From: [REDACTED]
Sent: 03 December 2018 13:16
To: Simon Davis
Subject: RE: Y/48/18/PL Maggies Meadow

The Parish Council response to this application stated that: "Insufficient detailed information provided within the application to determine the size of plant and volume of waste that the proposal will have capacity for. YPC also have grave concerns that there is not currently a dwelling and/or building at the proposed location for this plant so question its need."

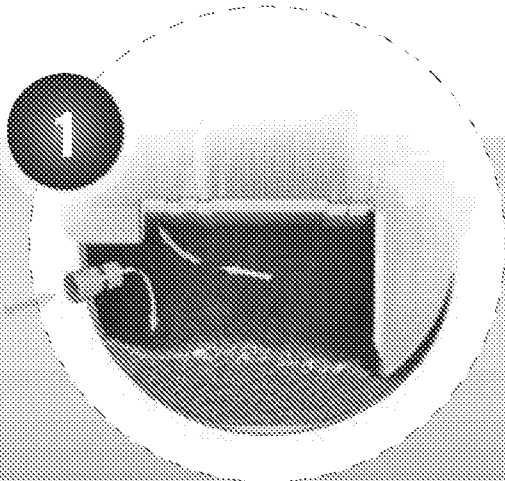
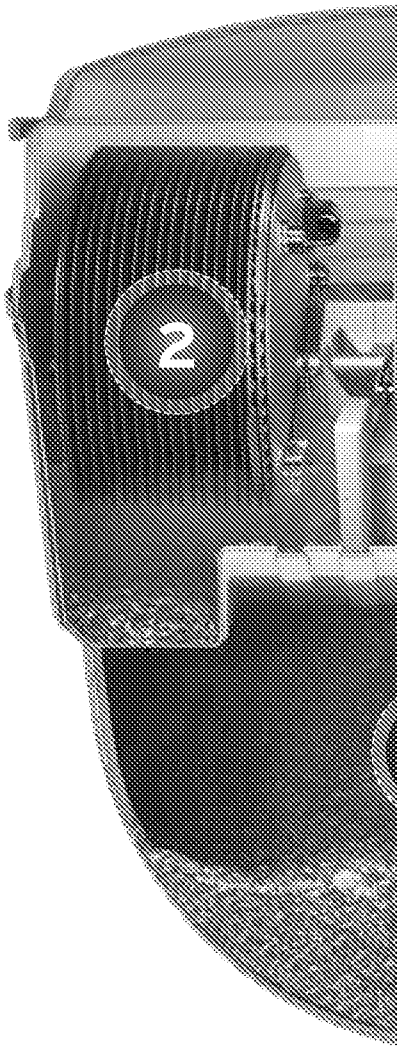
I have received this comment from the Chair of Yapton's Planning Committee – "As long as the capacity of the unit is only for 1 WC and not for 5+ then happy to remove our objection."

I can confirm the smallest unit size . Overall diameter width = 1995mm. Empty Weight 325kg. See page 6 of the attached document.

Please note the sewage treatment plant will be installed to facilitate the WC in the proposed agricultural barn. This was discussed with the case officer dealing with the project prior to this submission.
